Item No. **Report of the Interim Director of Planning, Regeneration & Public Realm**

Address LAND AT REAR OF 44 AND 45 ZEALAND AVENUE HARMONDSWORTH

Development: Erection of 2 no. bungalows with associated parking, landscaping and boundary treatments

LBH Ref Nos: **76673/APP/2021/3132**

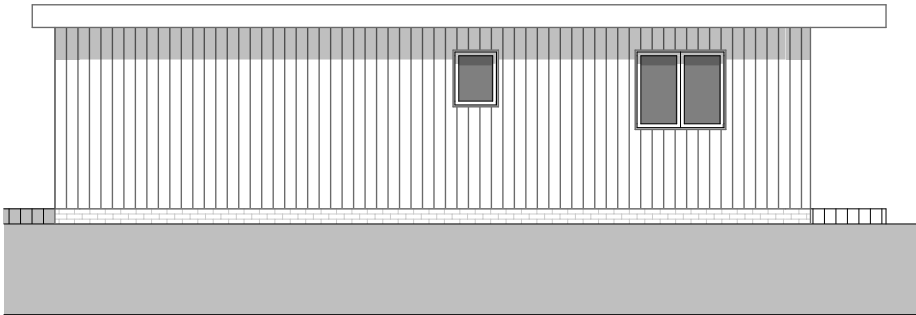
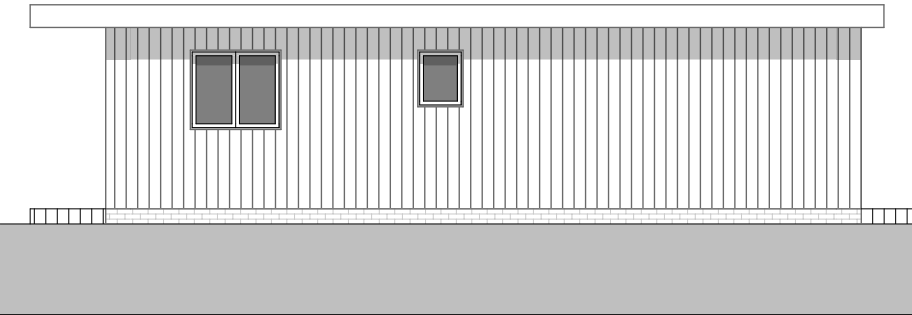
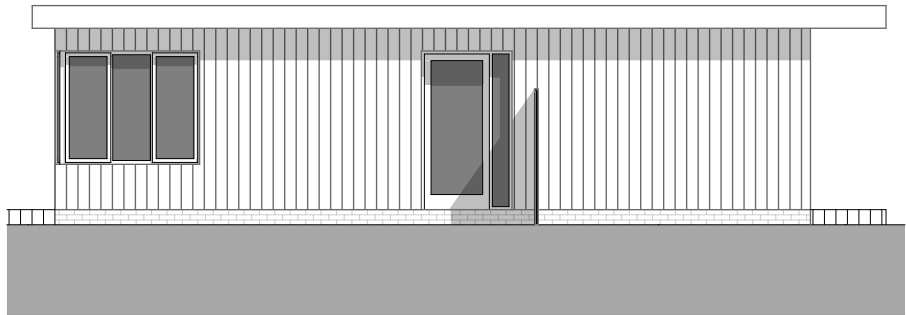
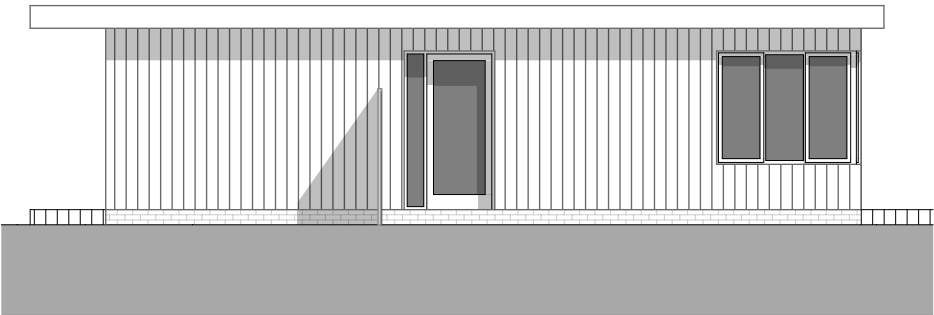
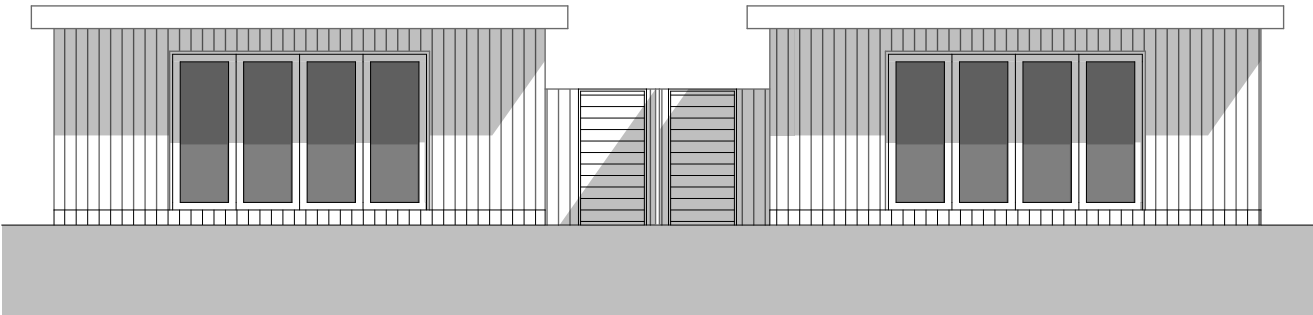
Due to their 2.9m single storey height, approximately 20m separation distance from properties on Zealand Avenue, 25m separation distance from the properties on Pinglestone Close, and the fact that the ground floor windows of the new dwellings would look toward boundary treatments, the proposed dwellings are unlikely to cause any undue loss of privacy to neighbouring dwellings that would justify a refusal of planning permission. Nor would the proposed development cause an undue loss of outlook or have any harmful overbearing impact on neighbouring dwellings.

The proposal includes two, single storey, flat roofed, detached dwellings of contemporary design. The area is characterised by two storey, pitched roof, traditionally designed, semi detached dwellings, as such the proposed dwellings would be out of character in terms of size and design. Furthermore the dwellings would have no frontage which contributes to the areas appearance and would therefore be out of character with other dwellings.

Drawn	Checked	Scale
ZL	ZL	As Shown
Drawing Number	Revision	Paper Size
J19019 - 001	A	A3
	Date	
	Mar 19

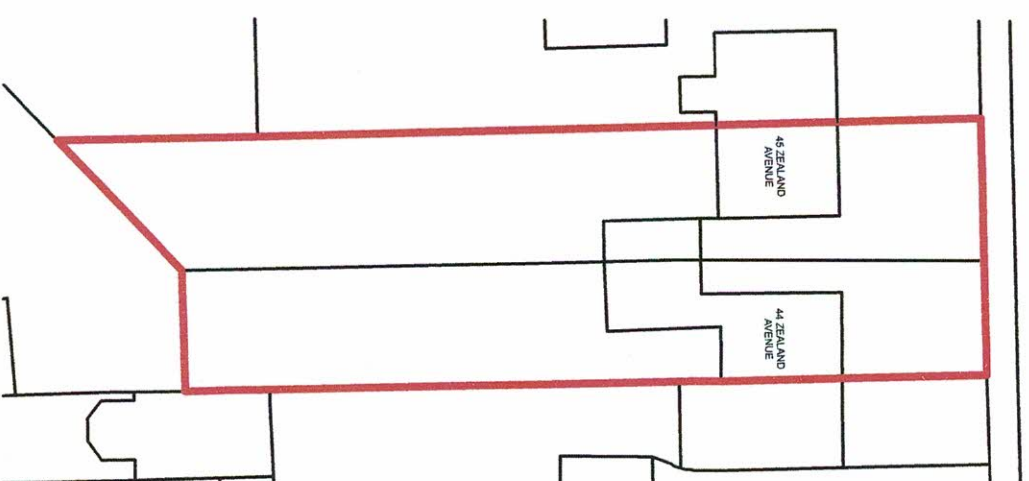
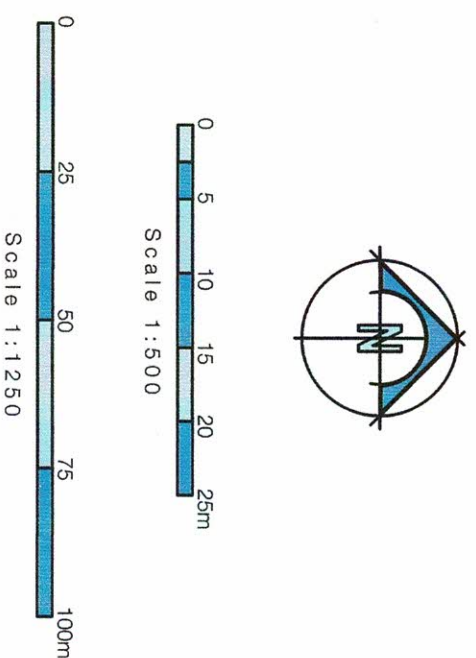
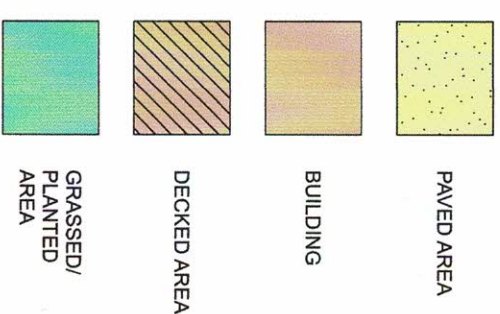
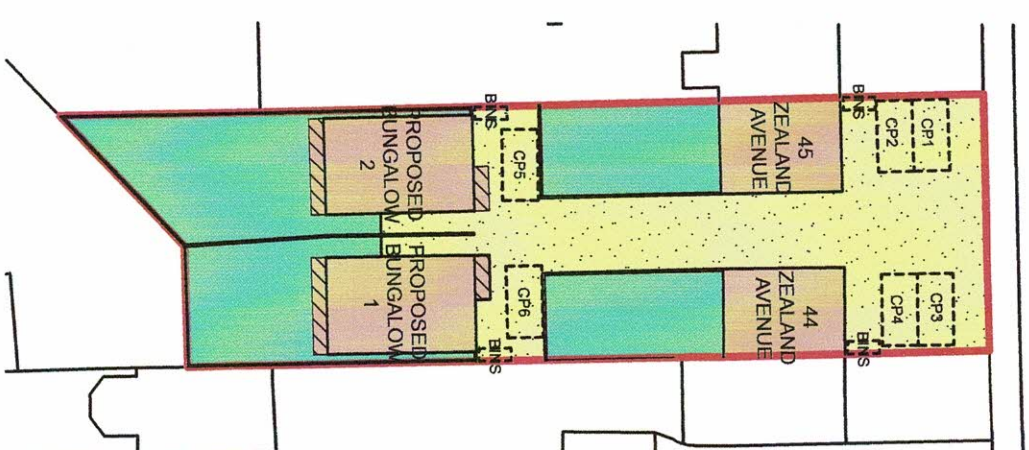
landscape could be re-introduced in the front gardens. The proposed bungalows have one car park space each. The car manoeuvring space appears to be sub-standard and space around the cars for access tight and inconvenient, at best. - Please refer to highway specialists. If these issues can be overcome by design the scheme may be acceptable subject to high quality landscape details. RECOMMENDATION Unacceptable as presented.

The applicant has not provided detailed and annotated car parking layout dimensions, however scaling off the plan it would appear that the new parking bay dimensions are substandard as shown, however the width of the site at the rear is measured as being approx. 17m, this length should be sufficient to accommodate 2x4.8m length bays and a 6m aisle length between them. The HA believes that there is sufficient scope for the applicant to satisfactorily address the car parking layout requirement and therefore could be conditioned. The applicant is required to show all dimensions annotated on the deposited plans.

No cycle storage has been indicated/shown by the applicant. The HA believes that there is sufficient scope for the applicant to satisfactorily address the cycle requirement and therefore could be conditioned. The applicant is required to show all dimensions annotated on the deposited plans.

On collection day, waste collection distances between a bin store (or suitable collection point) and a refuse vehicle should not exceed 24m to accord with waste collection standard. As presented, this parameter is exceeded given that refuse vehicles cannot gain access in relative proximity to the address. New occupiers would then be required to move their waste to a position within the 10m rule. It is considered that for this relatively small scale of development, it is in the best interest of the occupiers to place their refuse within the 10m distance parameter if they wish for their refuse to be collected.

Before the occupation of the proposed development, car parking and cycle storage layouts in accordance with Policy DMT6 and EV charging point shall be submitted to and approved in writing by the Local Planning Authority. The car parking layout, EV charging points and cycle parking store shall be constructed and laid out in accordance with the agreed details and completed prior to occupation of the development hereby approved and shall thereafter be retained, maintained, and kept available for the occupants of the development at all times.'
